Appeal Decision

Appeal Ref: 6005509

Land West of Browns Yard, Seas End Road, Moulton Seas End, Spalding, Lincolnshire, PE12 6LD

- The appeal is made under section 78 of the Town and Country Planning Act 1990 (as amended) against a refusal to grant planning permission.
 - The appeal is made by D Brown (Building Contractors) against the decision of South Holland District Council.
 - The application Ref is H13-0994-25.
 - The development proposed is the change of use of existing agricultural land to builders yard.
-

PROJECT	Change of use Land North of Seas End Road Moulton Spalding
DATE	September 2025
TITLE	Existing and Proposed Site Plan
SCALE	1:500
ORIGINAL SIZE	A1
DRG STATUS	PLANNING
DRAWING NUMBER	LDC4786-01A

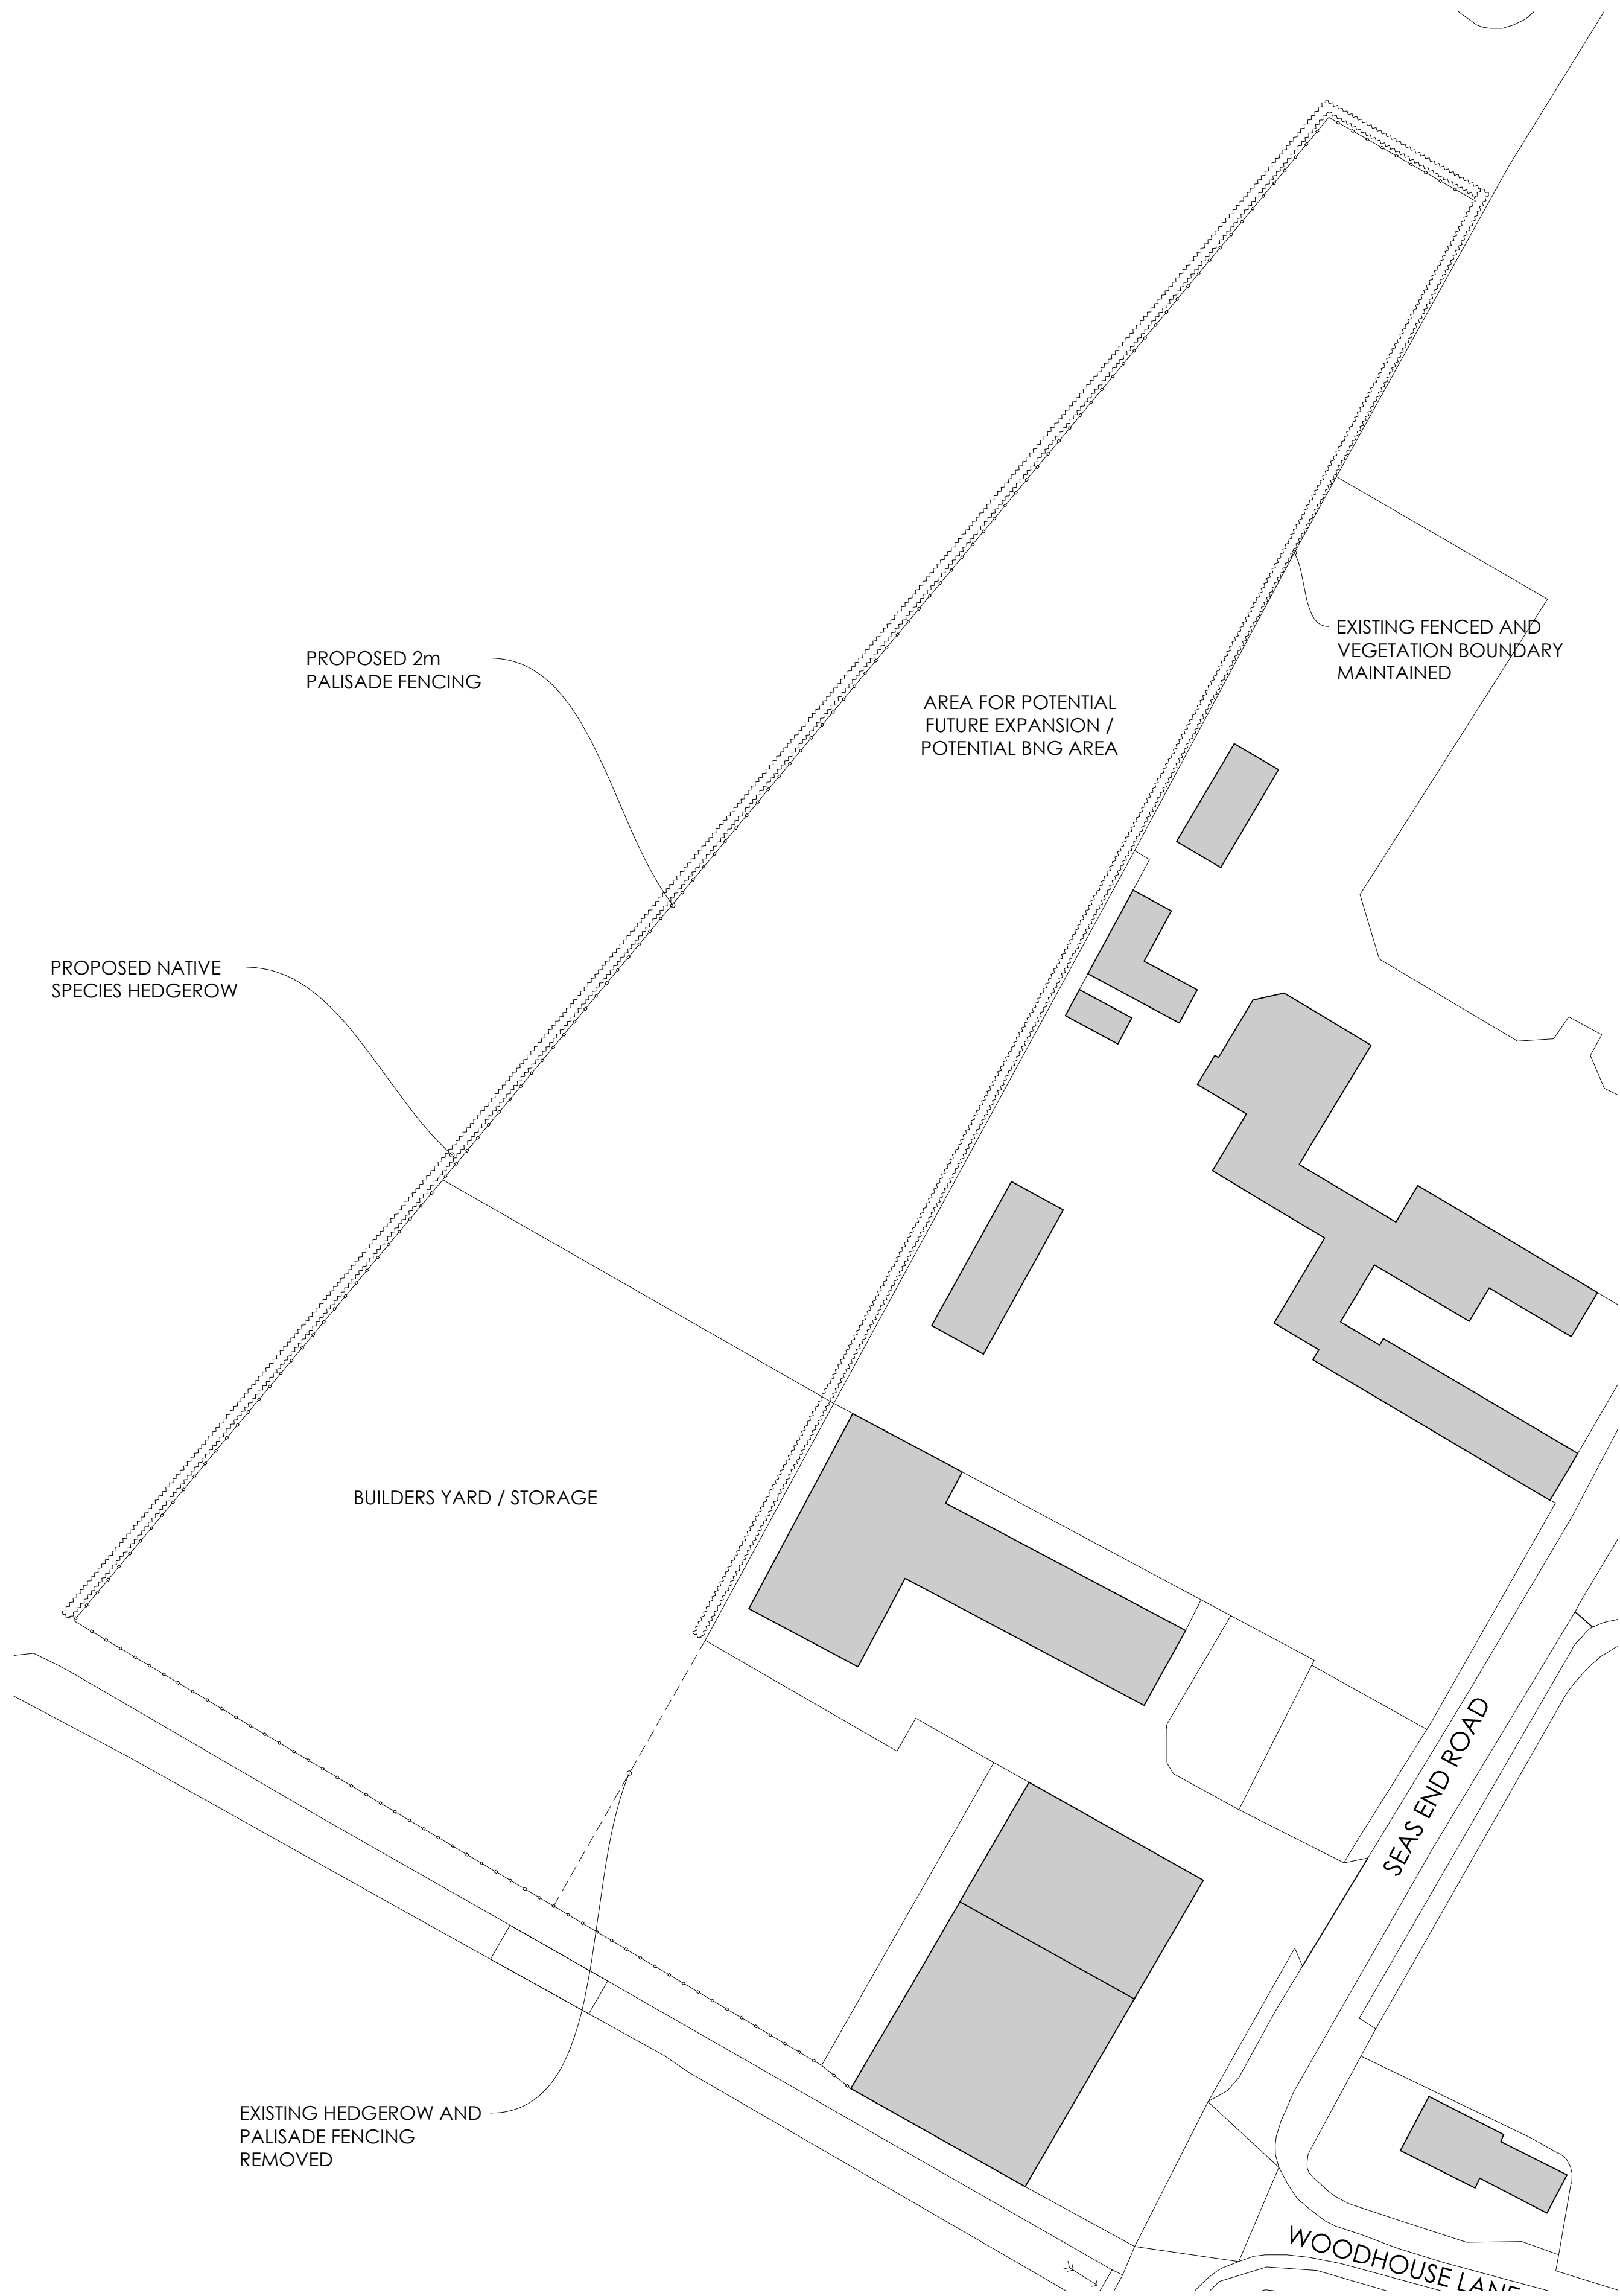
5. The scale of the proposed yard extension, by reason of its depth and width, would erode the strong and established rear boundary of the existing development and result in encroachment into the surrounding landscape. The introduction of additional palisade fencing would further intensify the industrial character of the site which would be at odds with its countryside context. While landscaping is proposed, this would take time to mature, and no details have been provided regarding the height of external storage. As a result, there is a clear potential for stored materials and/or commercial vehicles to exceed the 2-metre height of the fencing and any associated planting, such that the visual impact which would be prominent, especially from the south-west, would not be adequately mitigated.

6. It has been contended that the proposal would result in improved visual containment compared to the existing situation. However, the application site currently comprises an undeveloped parcel of open land and therefore does not give rise to the visual impacts claimed. Moreover, no proposals are put forward to strengthen the boundaries of the existing yard beyond the application site. In these circumstances, the development would intensify industrial features within an otherwise clearly rural setting, thereby exacerbating the visual harm rather than mitigating it.

15. Even setting aside the land shown on plan as being for a potential future expansion and/or biodiversity net gain (BNG), the land take is sizeable, representing a significant expansion into the open countryside. Compared to the existing yard, the proposed area for development would more than double. It would not be modest and brings into question whether such a sizeable development can be considered sustainable growth in the context of an expansion.

21. Had I been allowing this appeal, consideration over access to a nearby watercourse for maintenance purposes would have been necessary given the proposed fencing lies within its easement. However, as I am dismissing the appeal, I have not done so, as it would not alter my findings.
